**Town & Country Planning Act 1990 (as amended)
Town & Country Planning (Development Management Procedure) (England) Order 2010 (as amended) - Article 35
Application for Certificate of Lawfulness for a Proposed Use or Building**

Development Application for a Lawful Development Certificate for a proposed infill extension to the rear; remove the existing flat roof that is in situ on this section of the property and replace with a pitch roof no higher than the other pitches on the property.

Location Craig Lea 1 Canons Close Aldwick

EXISTING PLAN

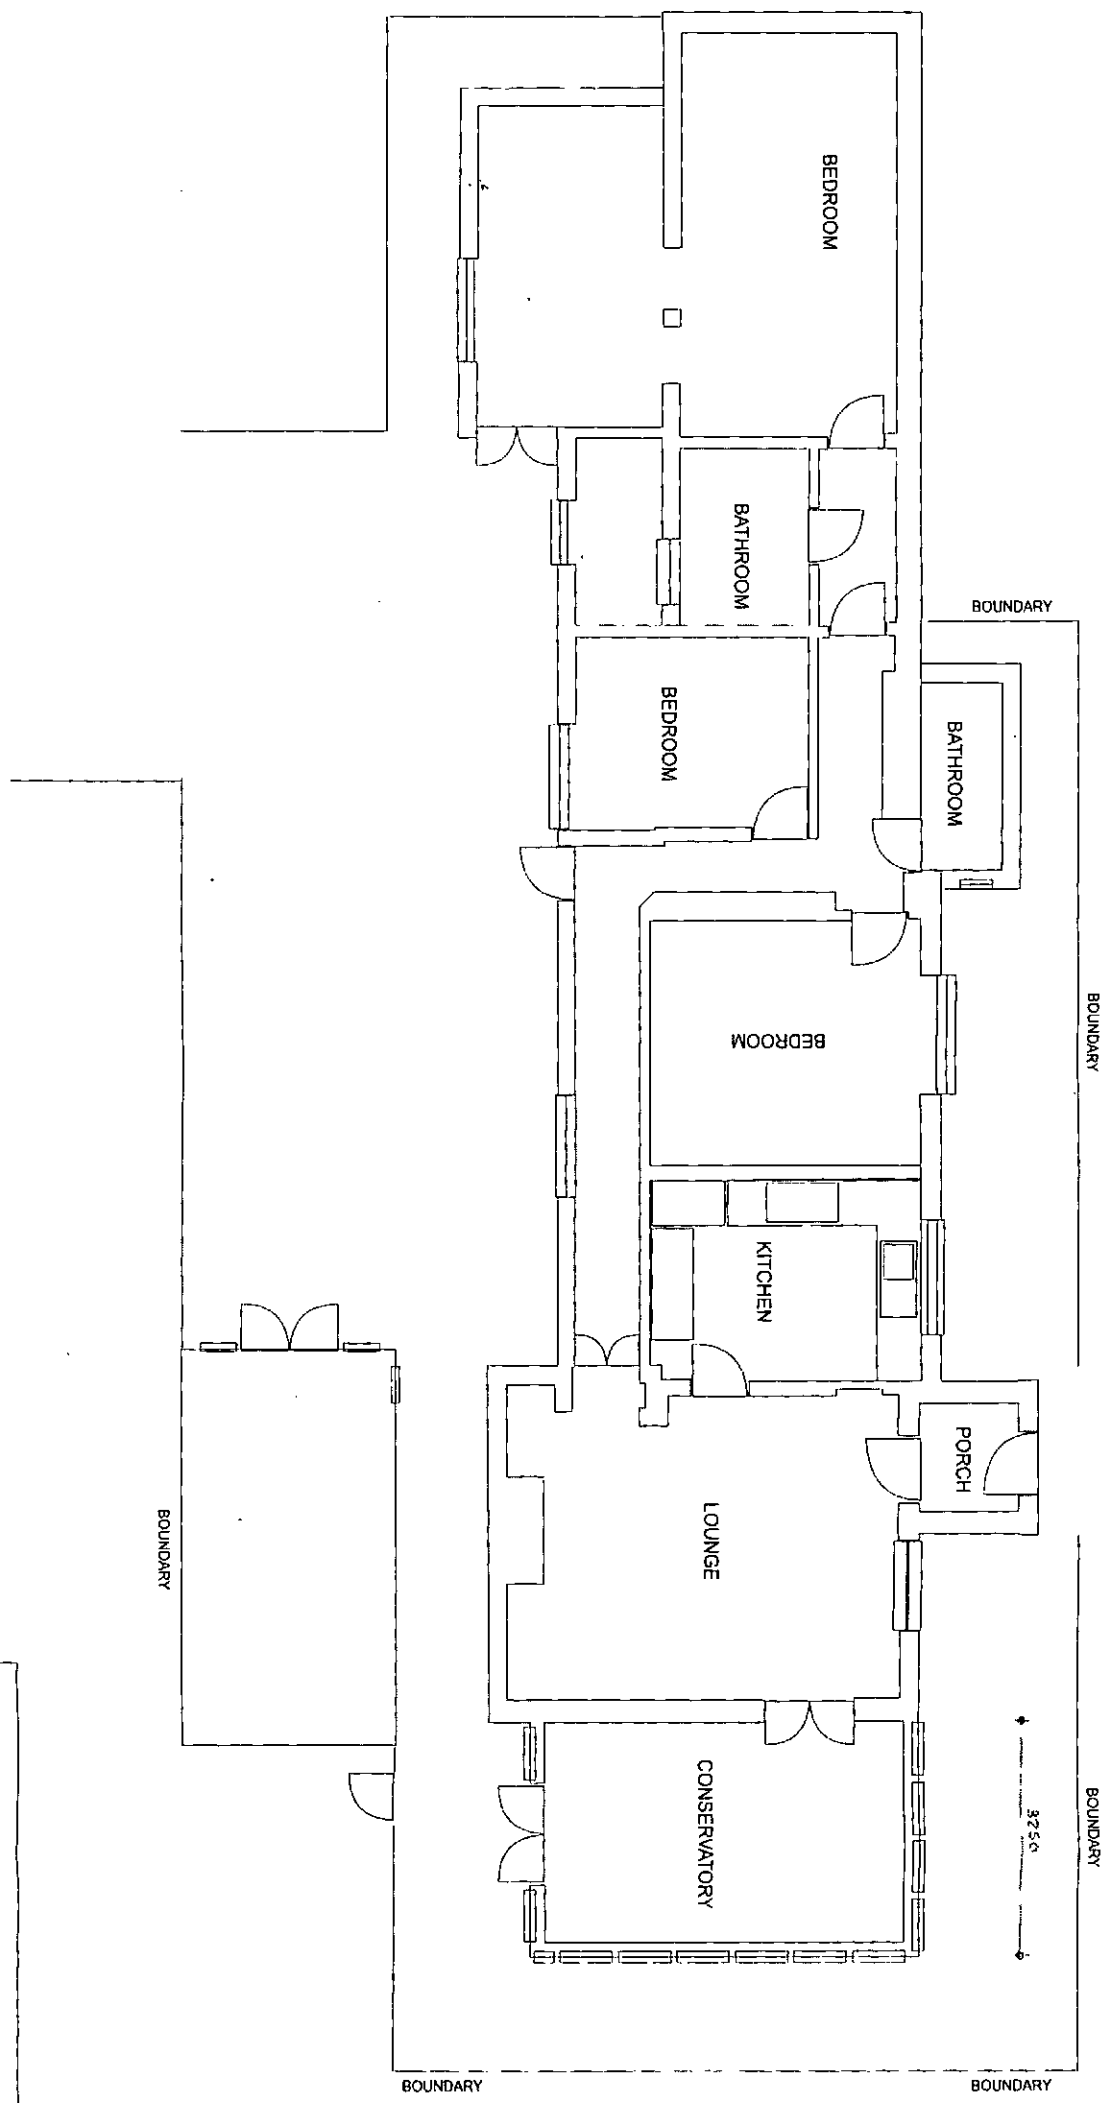
The existing and proposed floor plans and elevations do not accord. Please amend accordingly.
